URBAN DESIGN BRIEF

SITE PLAN CONTROL

SUBJECT SITE: 541-561 SOMME STREET

REPORT DATE: APRIL 21, 2025

scale	drawn by D.A.
date	checked by M.R.
project number RL — — — RA	drawing number L-01

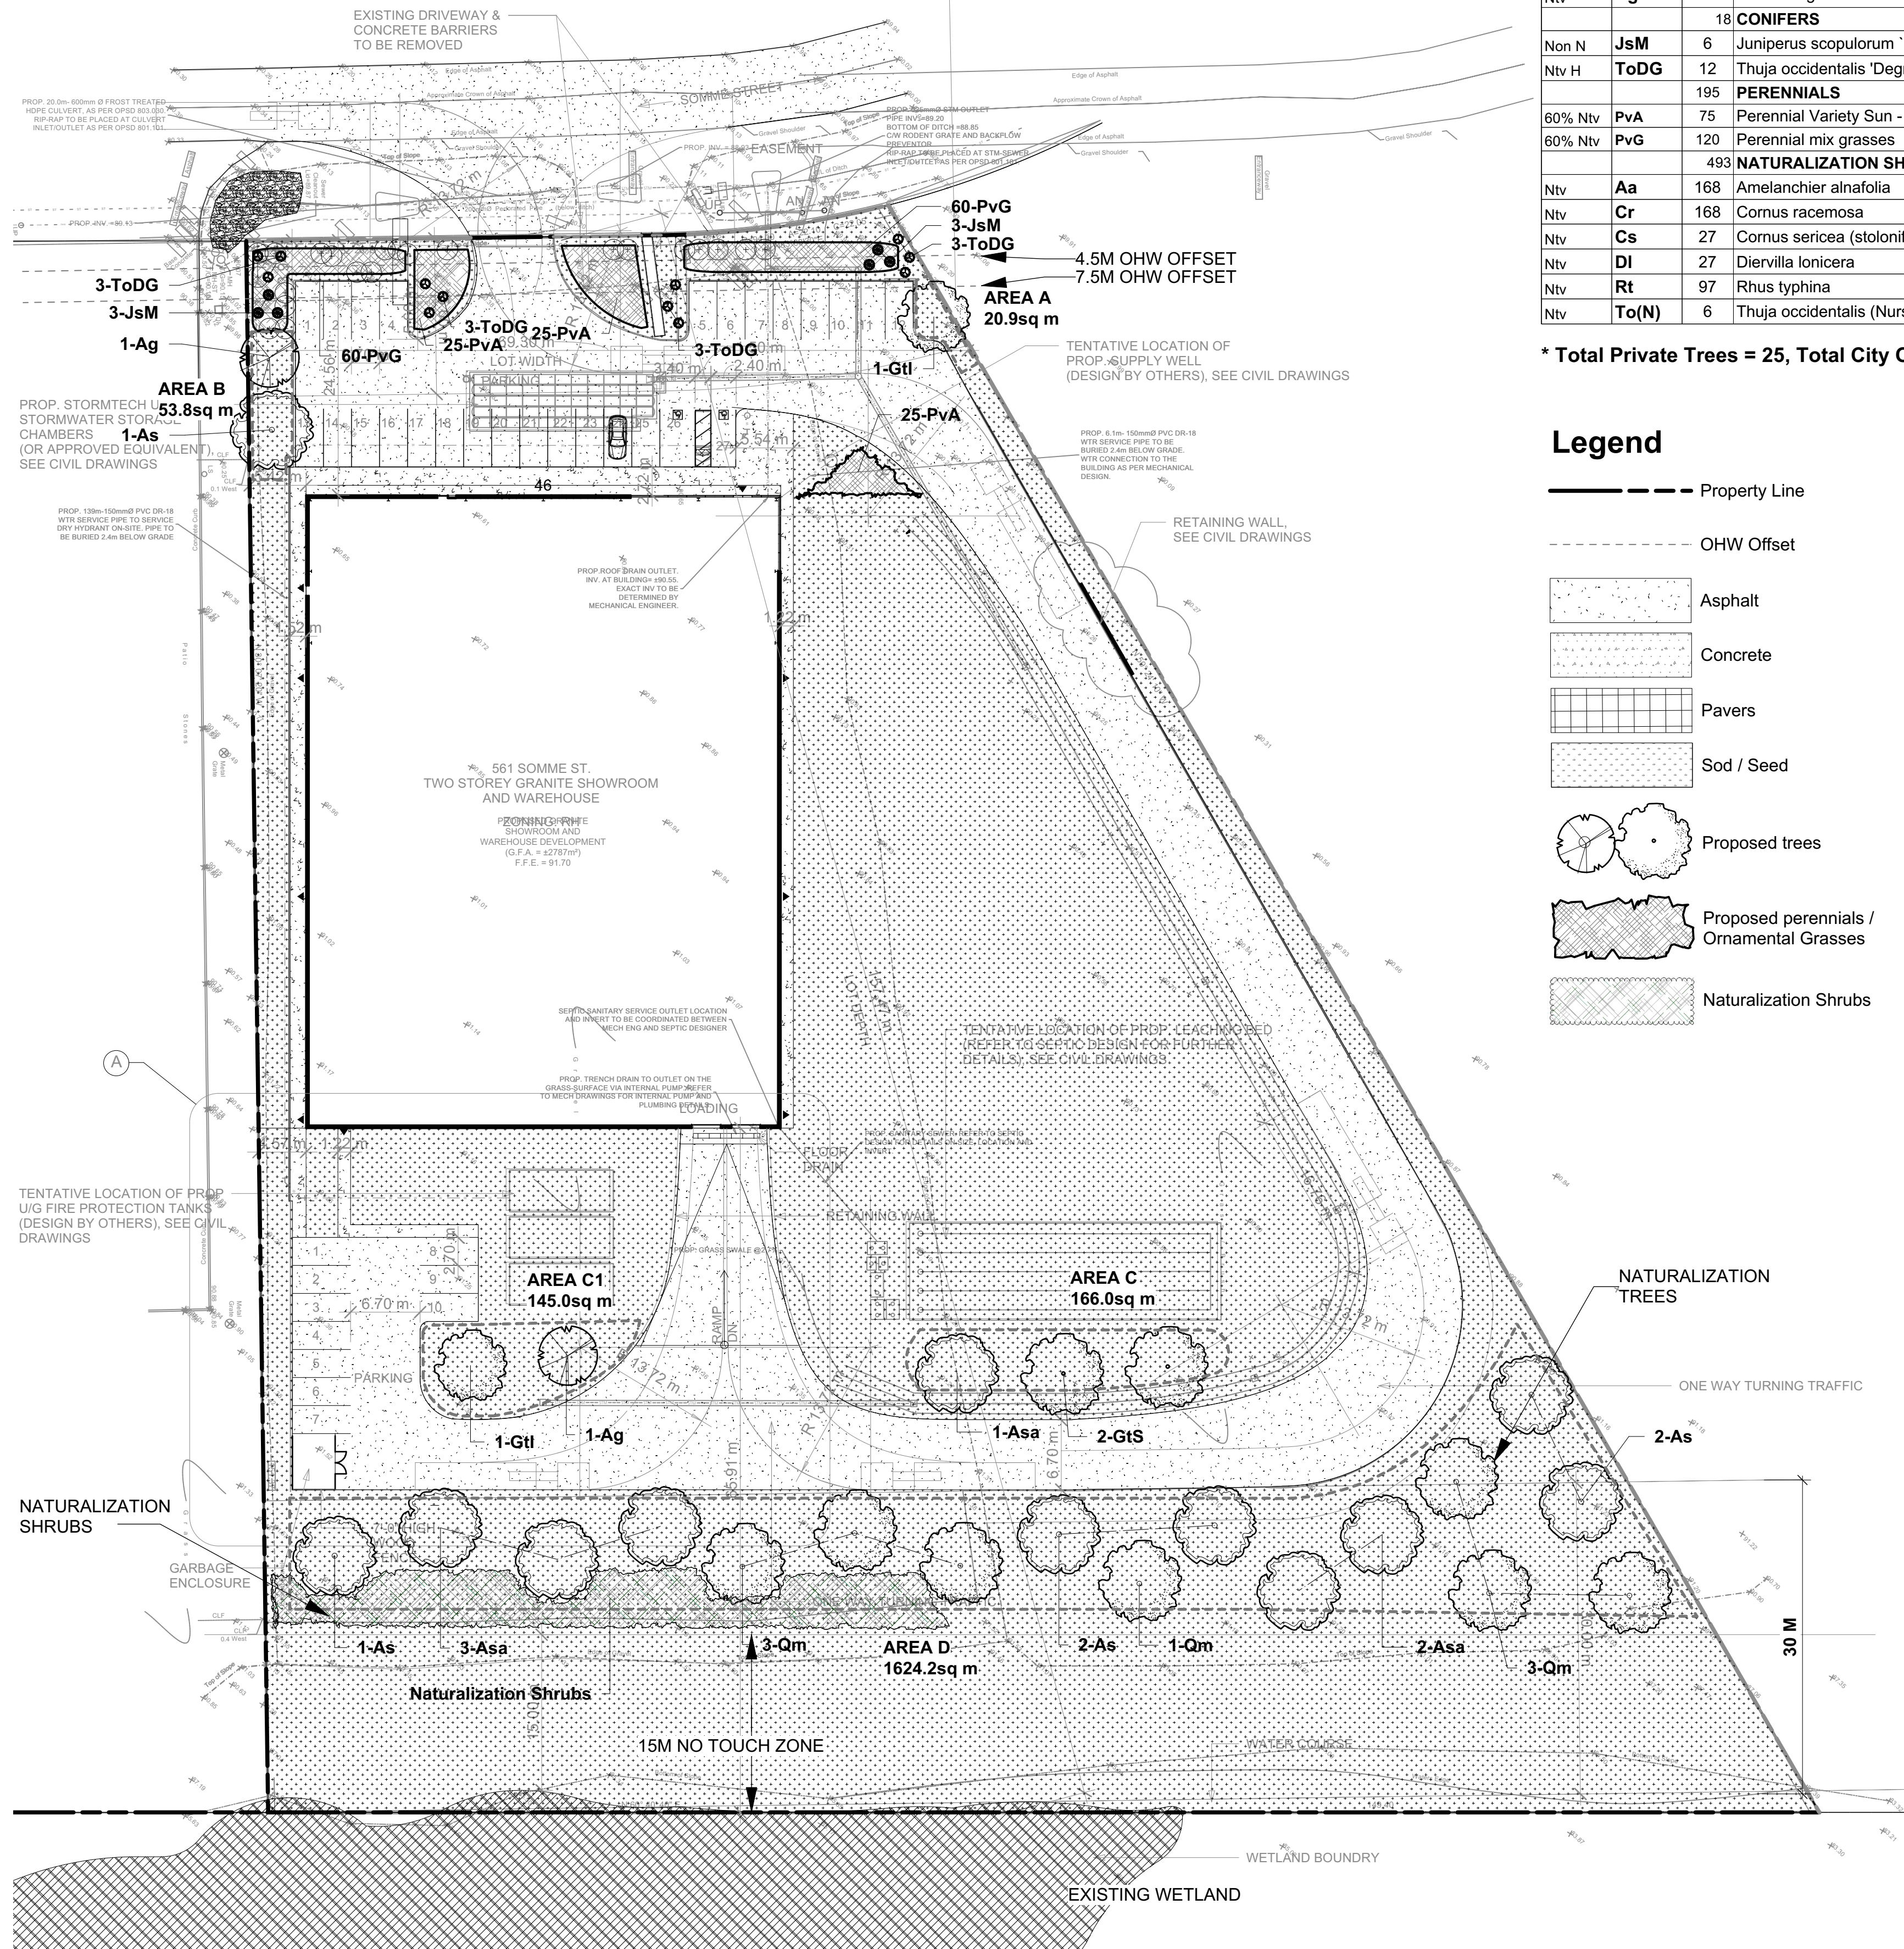
We recommend providing landscaping and new tree planting at the front of the property.	Trees and landscaping have been added to the front of the property. In working with HydroOttawa, we have learned that there is an easement, poles and tie-backs that significantly encumber the frontage. Therefore, no landscaping is provided where hydro infrastructure is existing.

What is happening in the large areas of land left over at the rear of the site and beside the building? Please indicate on the site plan/landscape plan and provide landscaping and trees if possible/suitable.	This area has been reserved for possible future development.
--	---
